Gatwick Airport Northern Runway Project

Response to the Examining Authority's Written Questions
(ExQ2) – Historic Environment

Application Document Ref: 10.56.8

PINS Reference Number: TR020005

Reproduced from Ordnance Survey map with the permission of Ordnance Survey on behalf of the controller of Her Majesty's Stationery Office © Crown Copyright (2023). License number 0100031673, 10001998, 100048492.

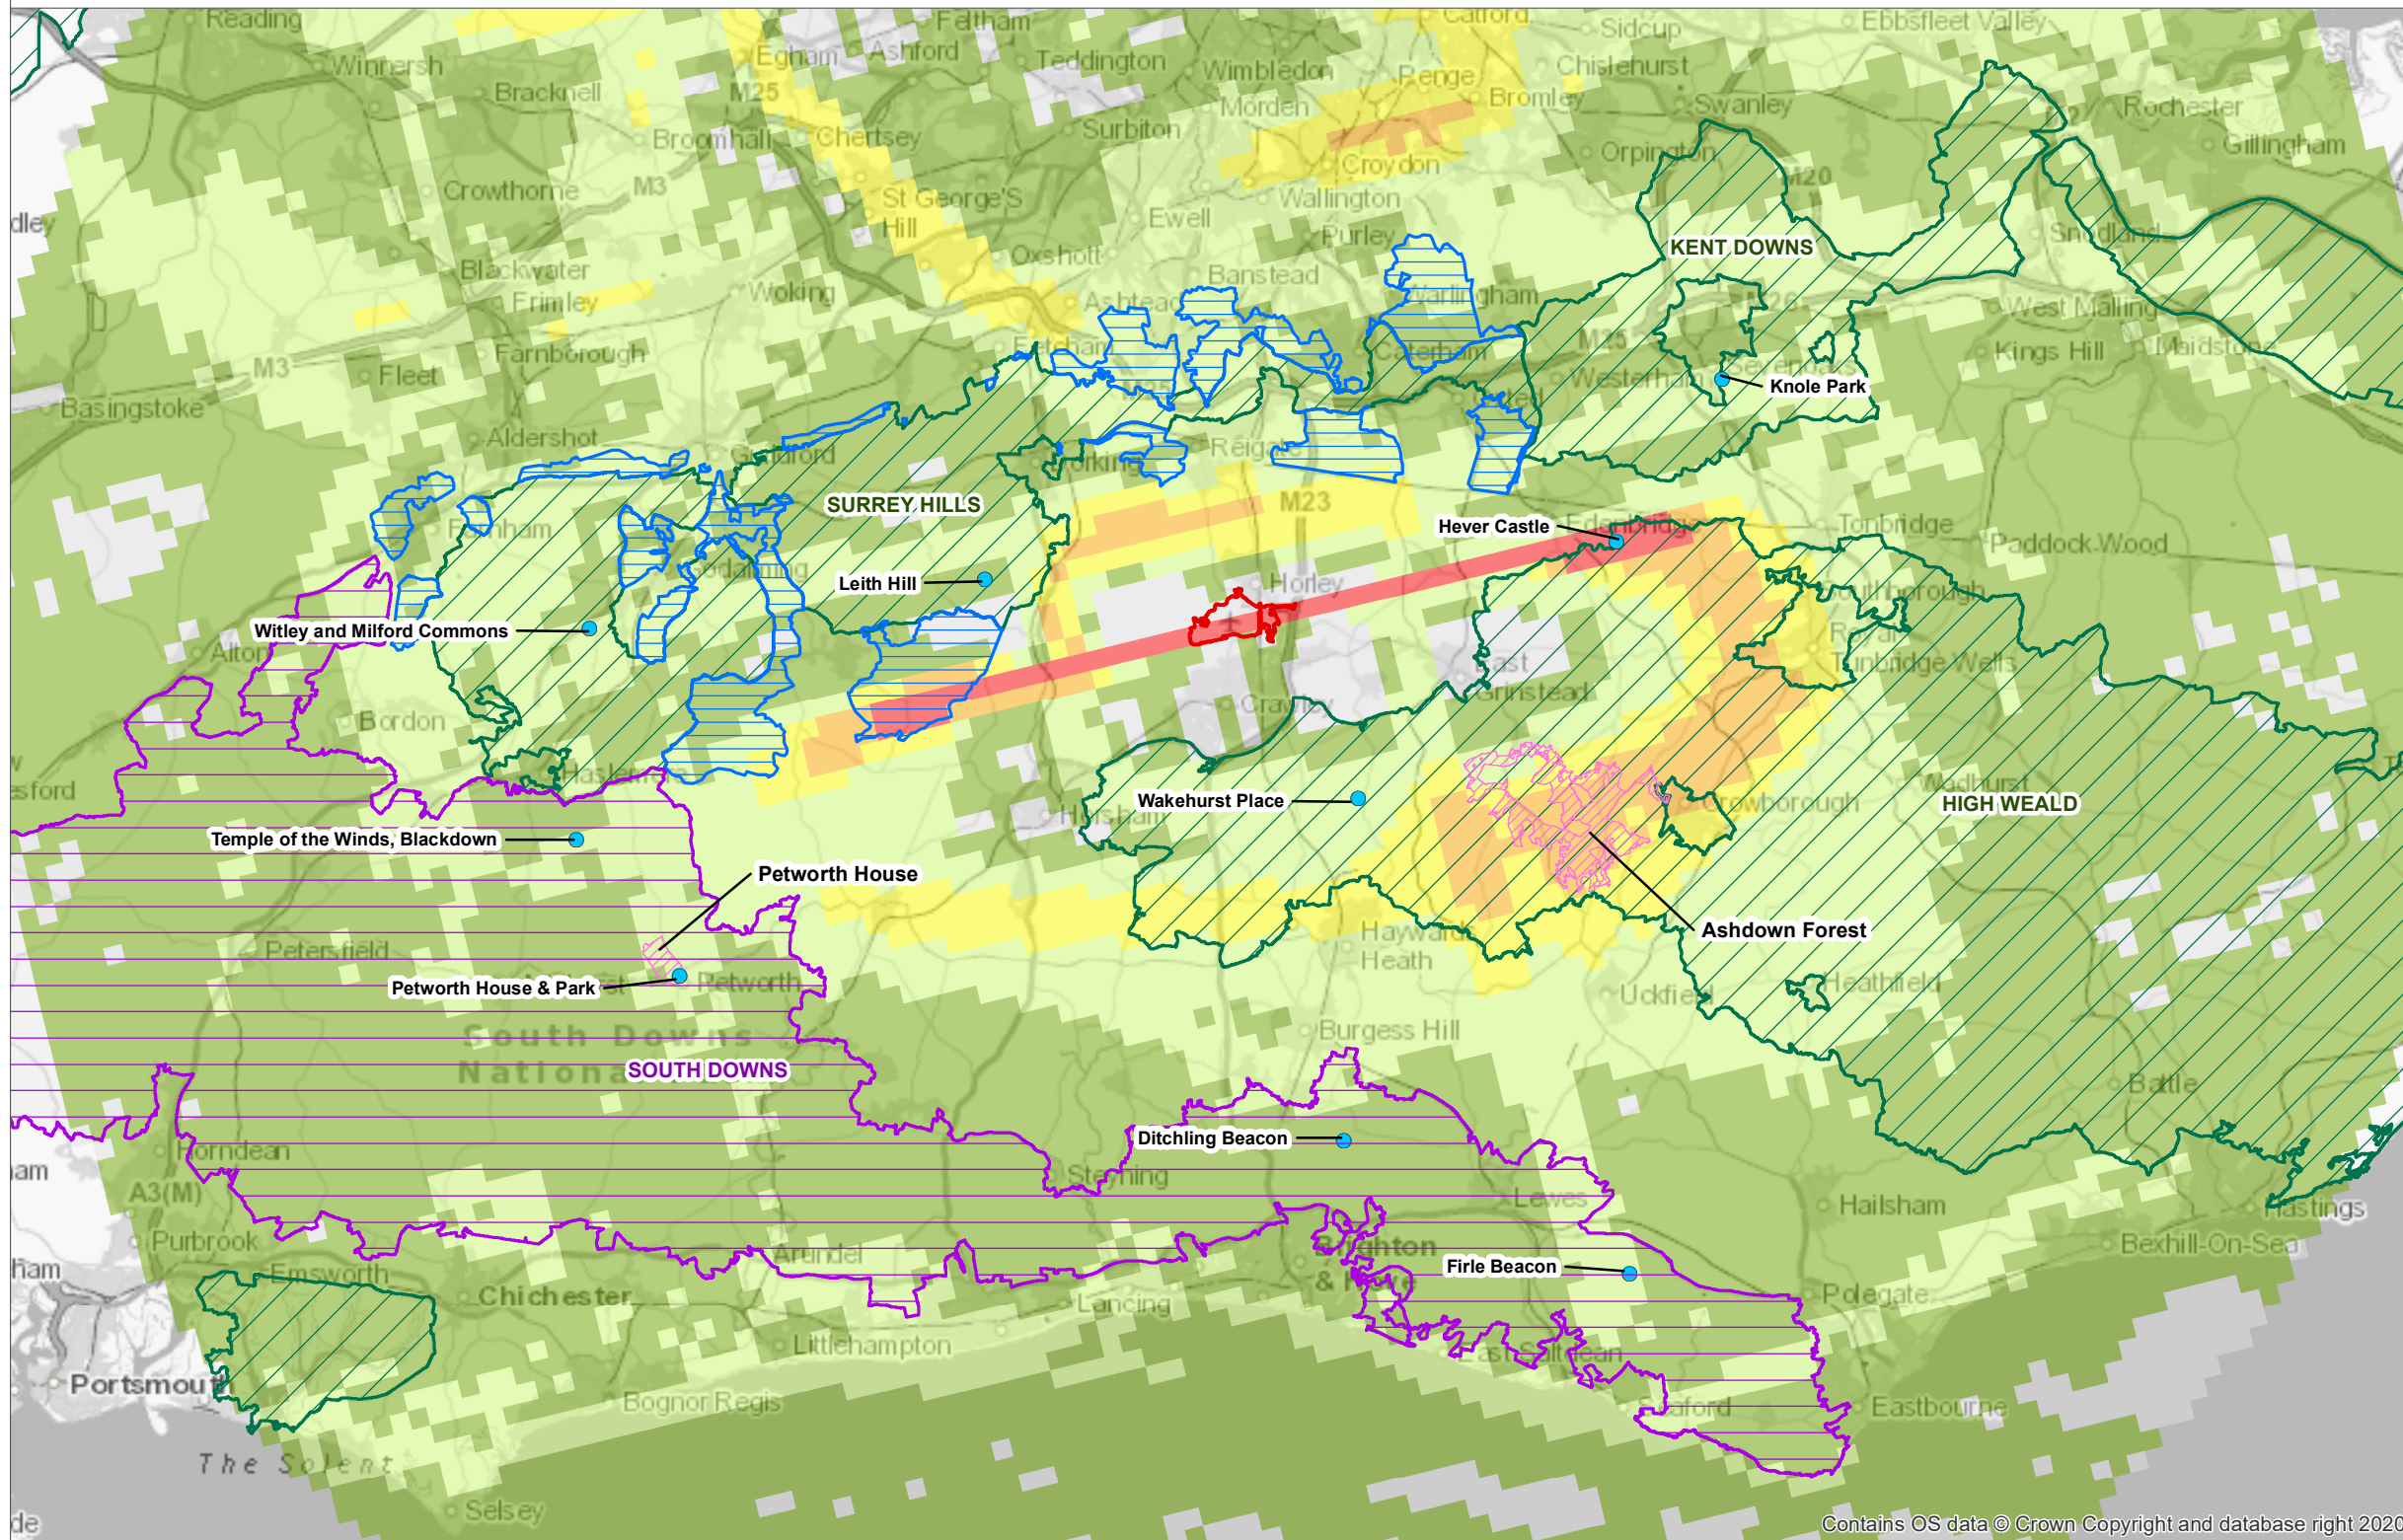
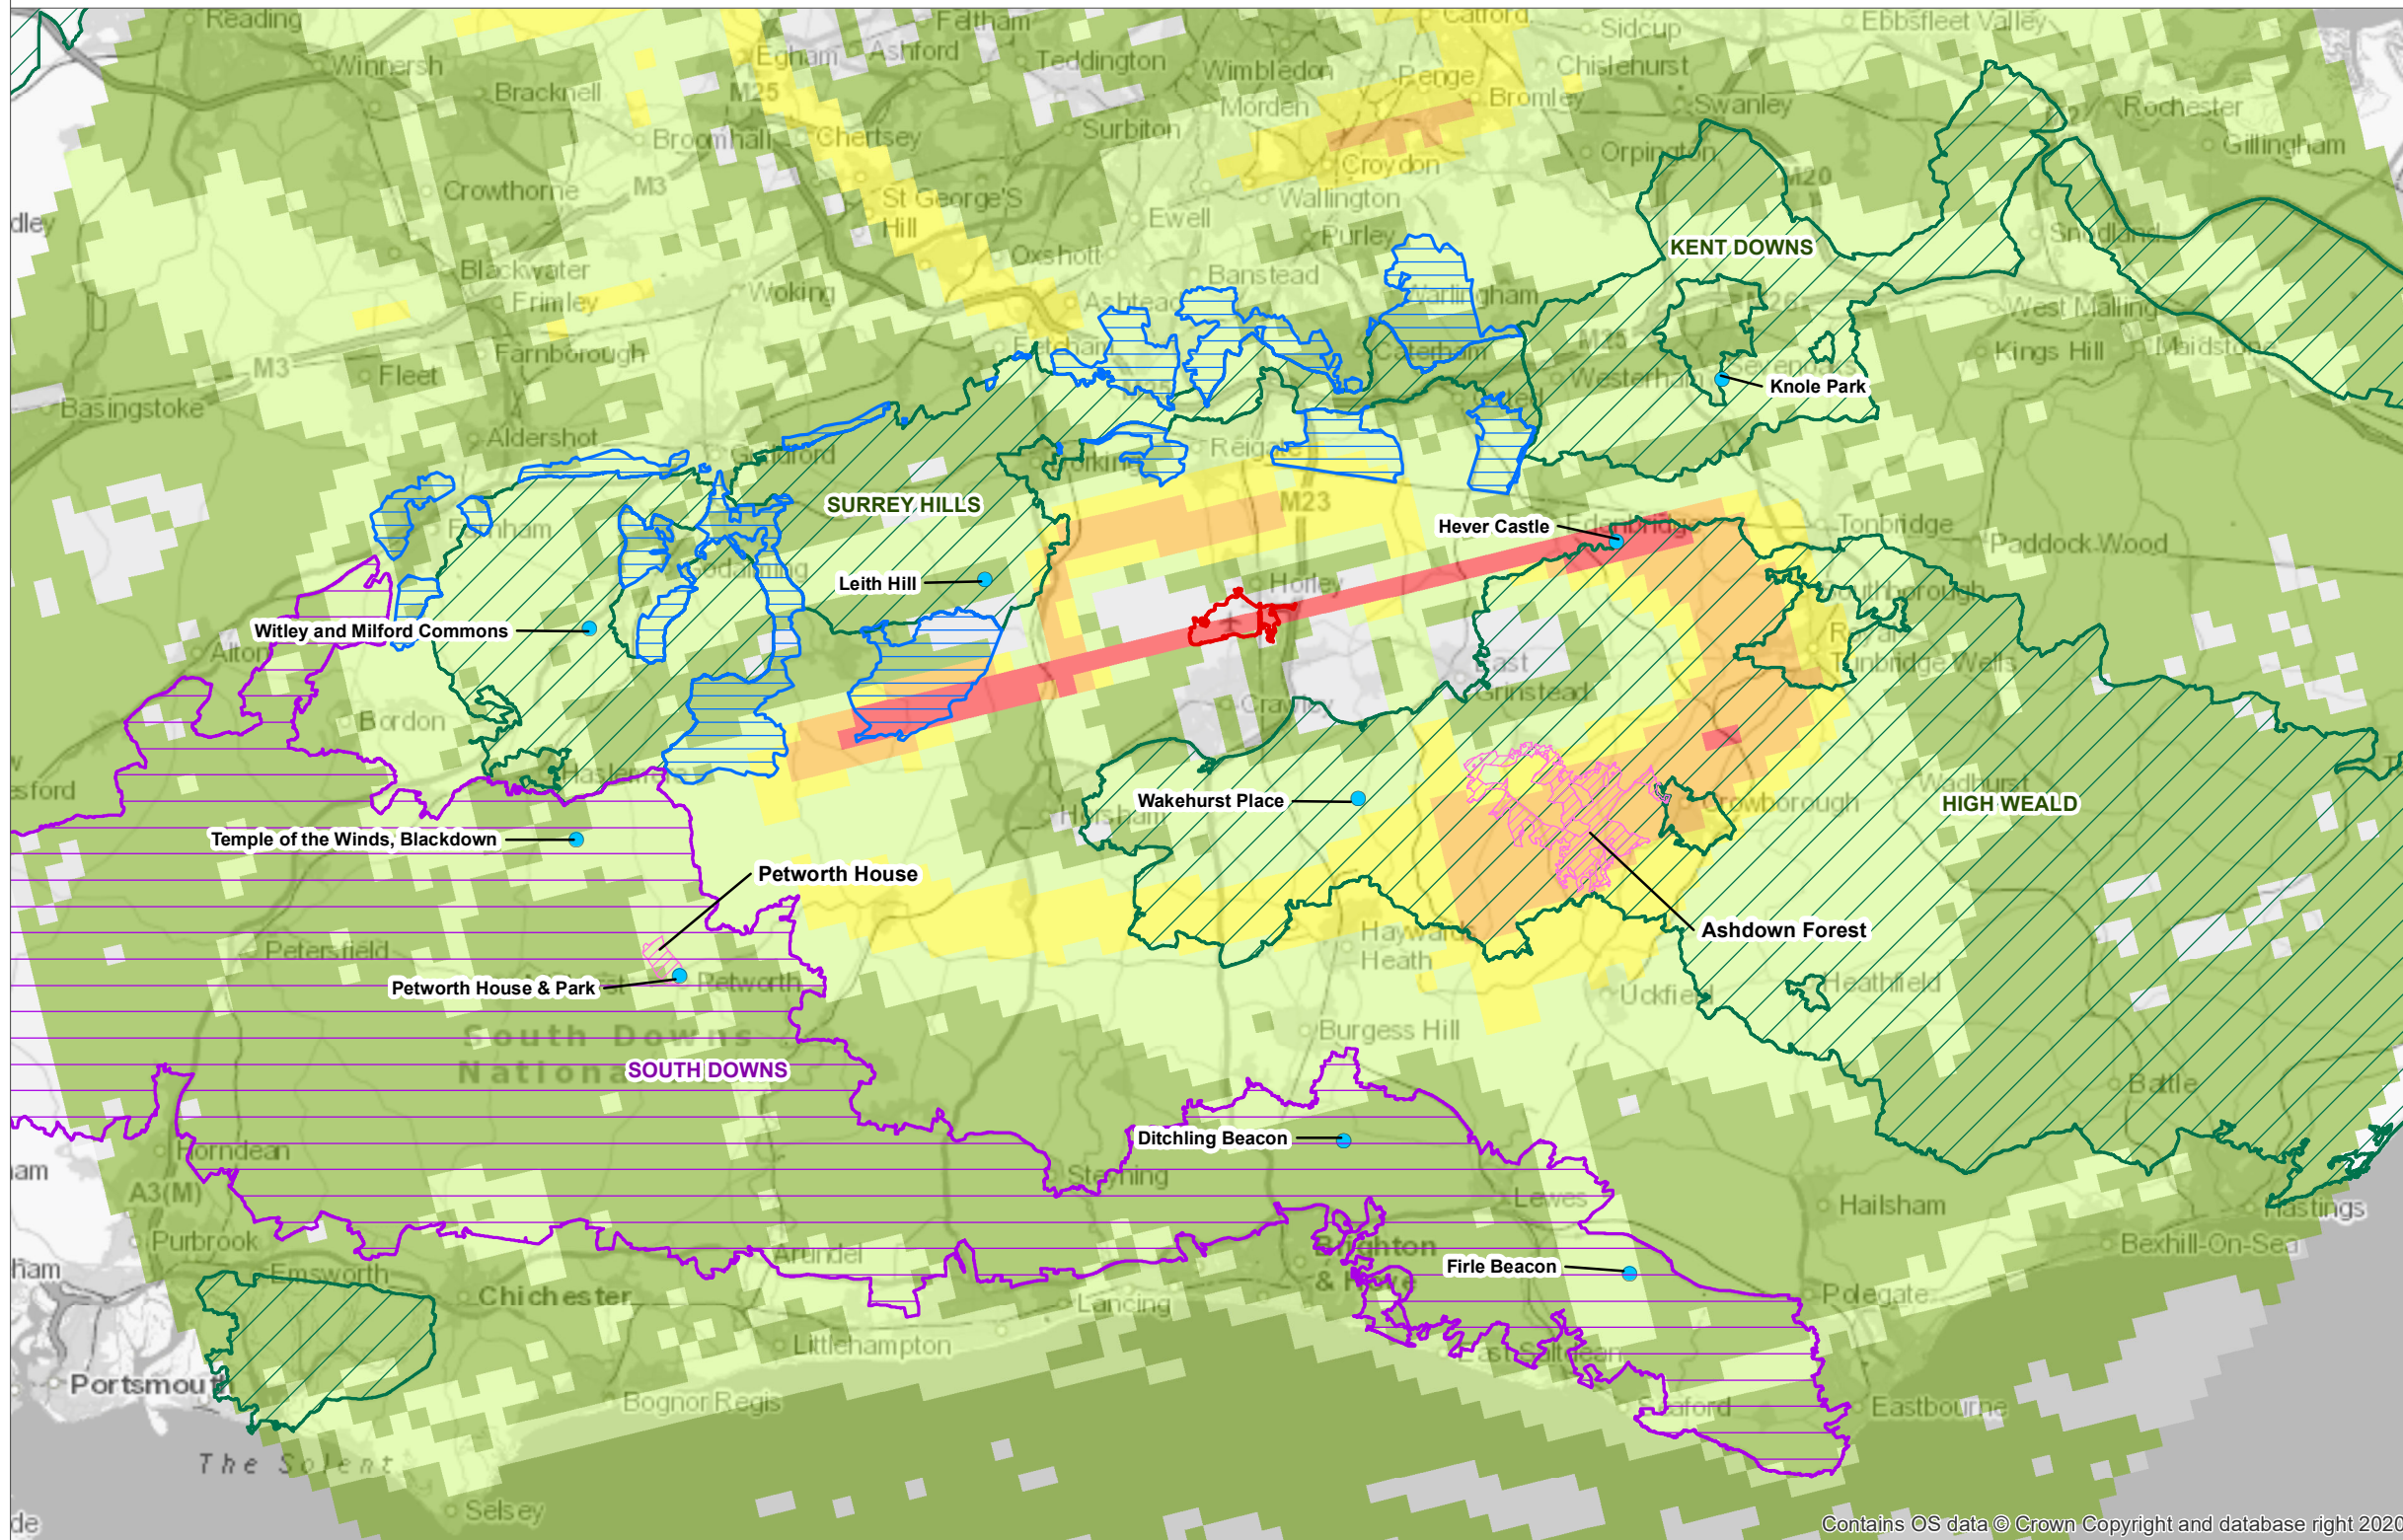
ExQ1	Question to:	Question:
HISTORIC ENVIRONMENT		
HE.2.1	Gatwick Aviation Museum	<p>Loss to the Gatwick Aviation Museum</p> <p>Your RR [RR-1496] states that any compulsory purchase of the land occupied by the museum would result in the loss of historic and educational resources to the nation.</p> <p>Please provide further details regarding such loss and confirm whether your previous comments are still valid.</p>
		N/A – this question is not directed at the Applicant.
HE.2.2	Applicant	<p>Hever Castle</p> <p>Provide clarification over the likely numbers of flights and ratio of such flights (arrivals and departures) likely to overfly Hever Castle as a result of the Proposed Development.</p>
		<p>ES Chapter 14: Noise and Vibration [APP-039] Table 14.12.1 provides estimates of summer season daily (24 hour) overflights including at Hever Castle, as follows:</p> <ul style="list-style-type: none"> • 2019 baseline - 309 • 2032 baseline - 325 • 2032 with Project – 389. <p>so showing a proportional increase of 20% overflights in the NRP scenario.</p>

<p>The overflight assessment considers all overflights, arrivals and departures, up to 7,000ft above local ground level from all airports. For the noise assessment (see ES Chapter 14: Noise and Vibration [APP-039]) arrivals and departures are modelled differently to compute total noise levels, but for the overflights assessment, which is not a noise assessment, the distinction is not necessary. At Hever Castle, the vast majority of overflights on an average summer day will be arrivals from the roughly 70% of days when the airport operates all flights in a westerly direction with far fewer departures on roughly 30% of days when the airport operates all flights in an easterly direction and when most departures turn before reaching Hever Castle. The increase in departure and arrivals overflights as a result of the NRP is expected to be 20% and the flight paths flown in this area will not change. The general orientation of flights are illustrated in Figures 8.6.3 to 8.6.7 of the ES Landscape, Townscape and Visual Resources Figures [REP2-007].</p>
